**Town and Country Planning Act 1990 (As amended)
Town and Country Planning (General Permitted development) Order 2015 Schedule 2 Part 1 Class A**

Prior Notification for a Permitted Development (Householder)

Development: Demolition of existing conservatory; Construction of rear single-storey flat roofed extension (5.2m D x 4,5m W) with roof light.
Location: 58 Felpham Way Felpham PO22 8QU

BLOCK PLAN (dashed line indicates proposed rear single-storey extension)  
Scale 1:500

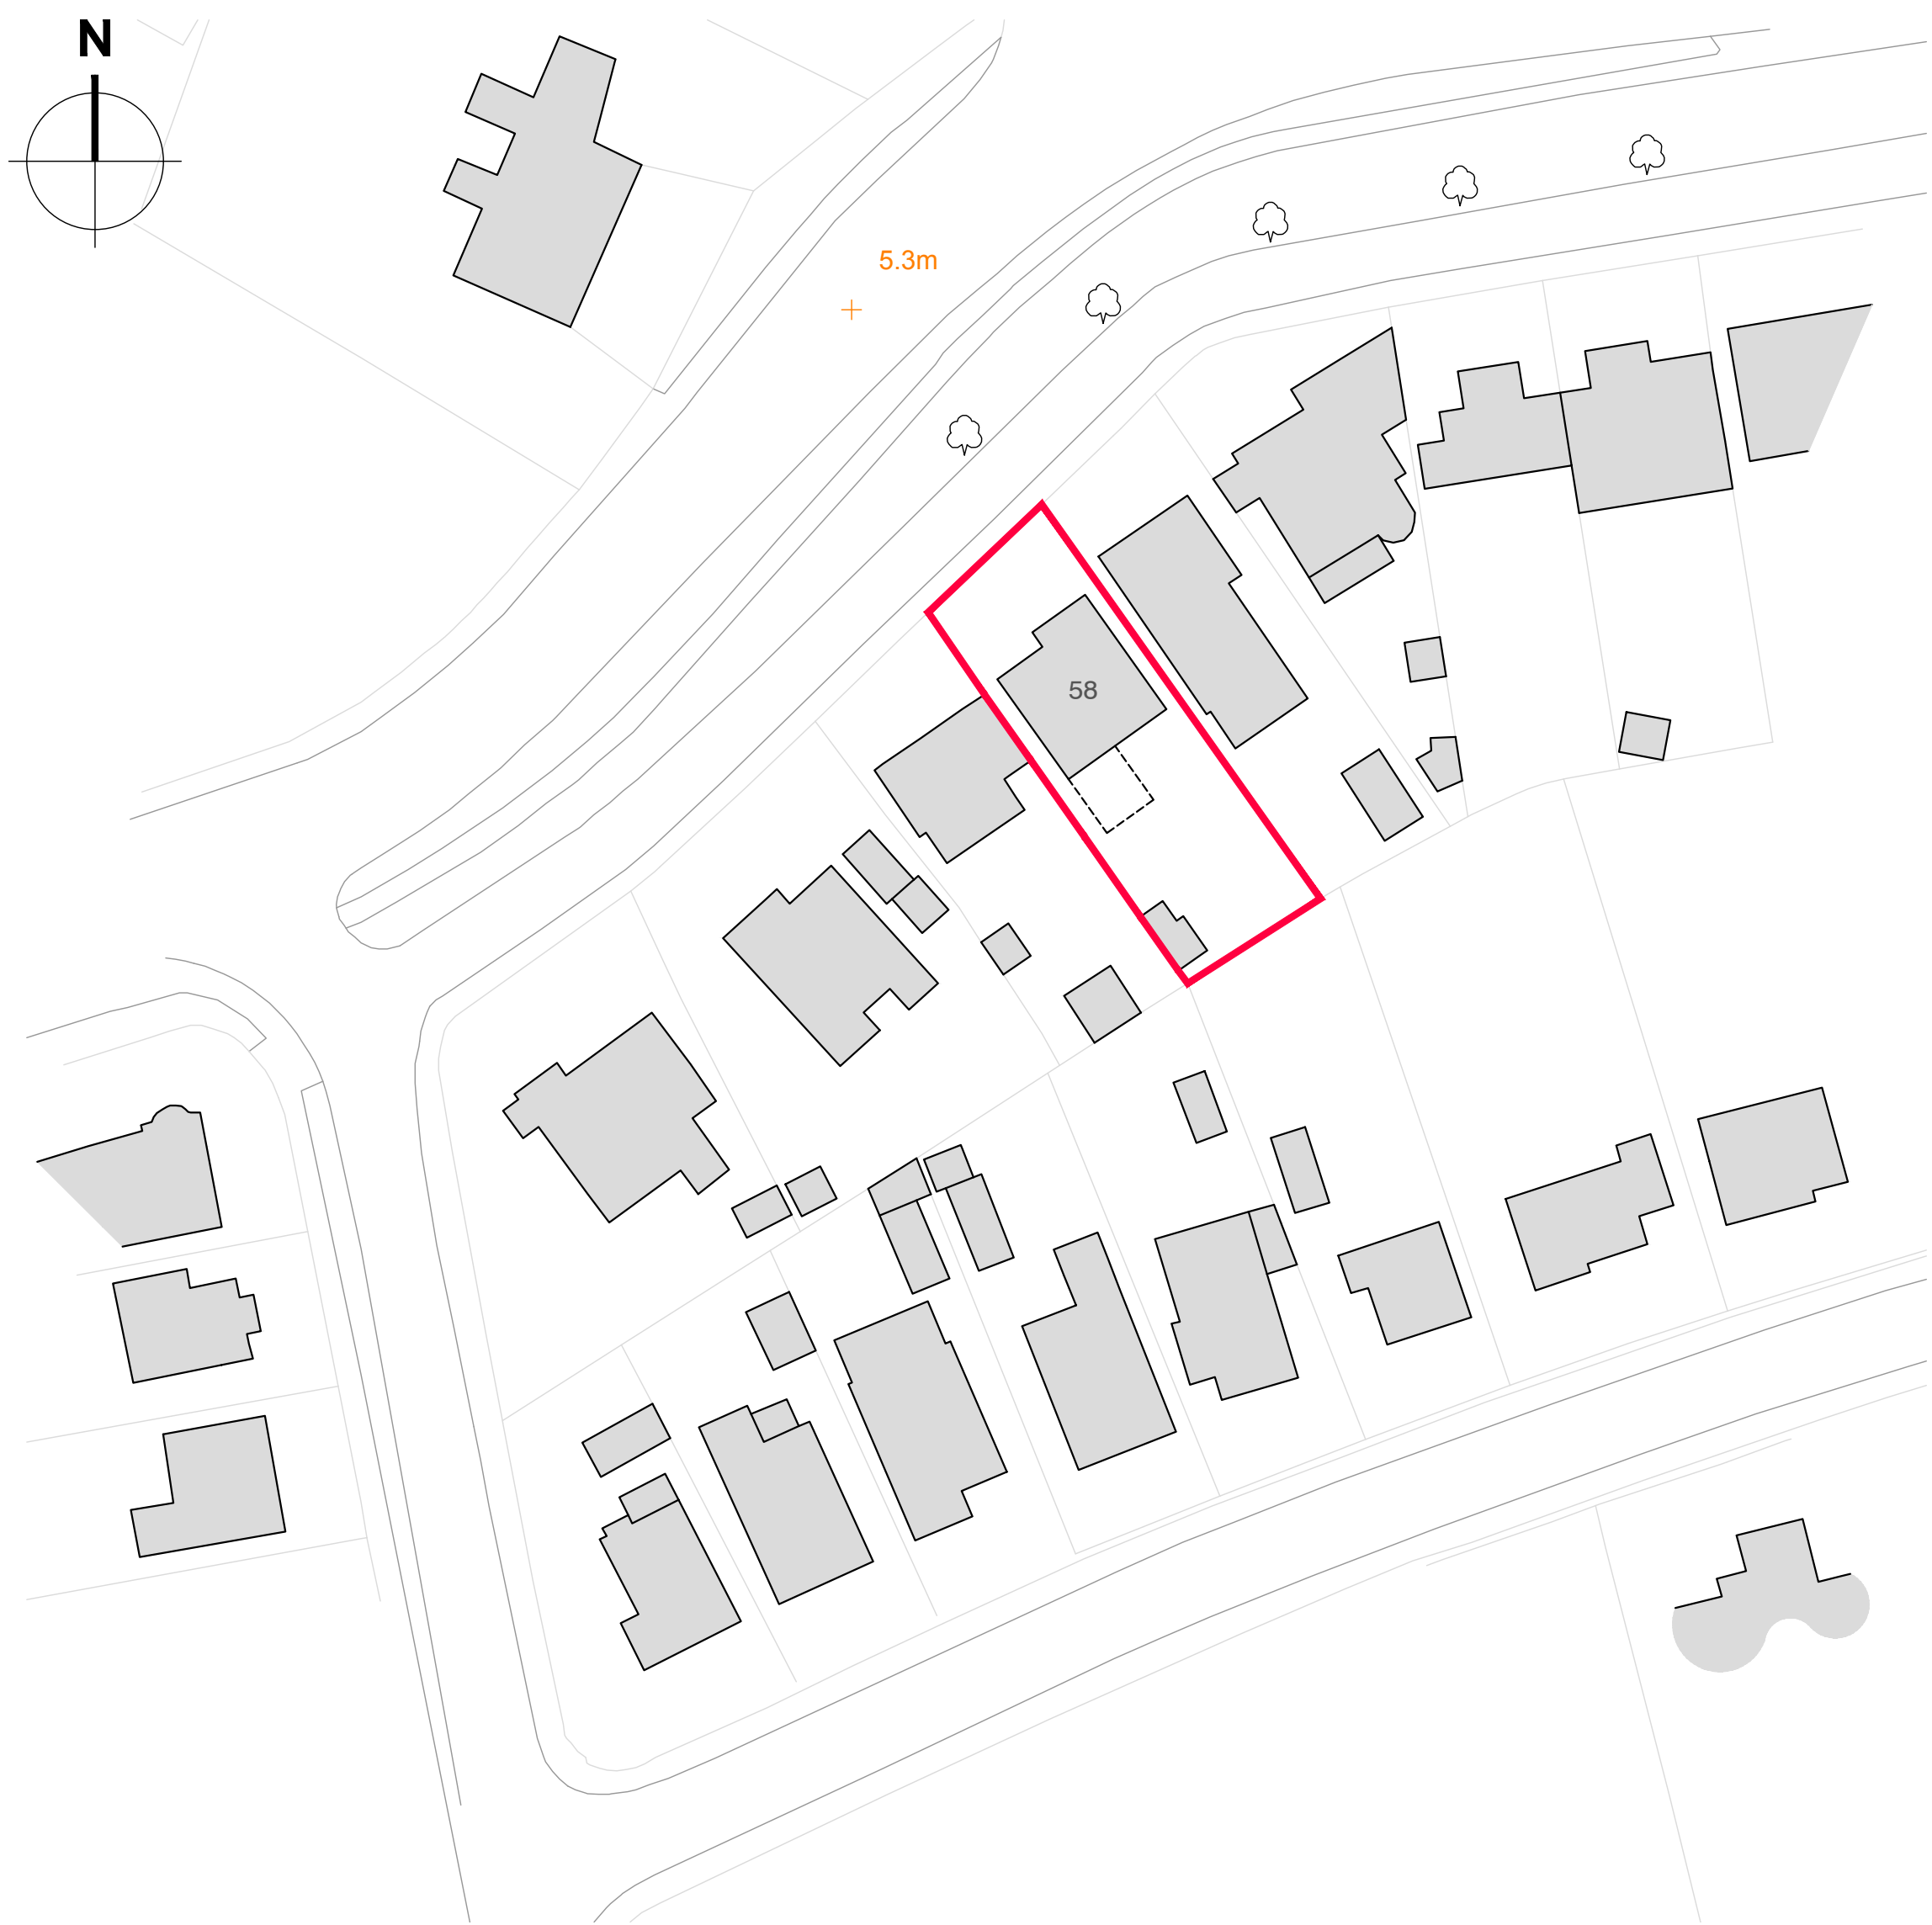
Block Plan

Please amend the block plan to show the proposed development.
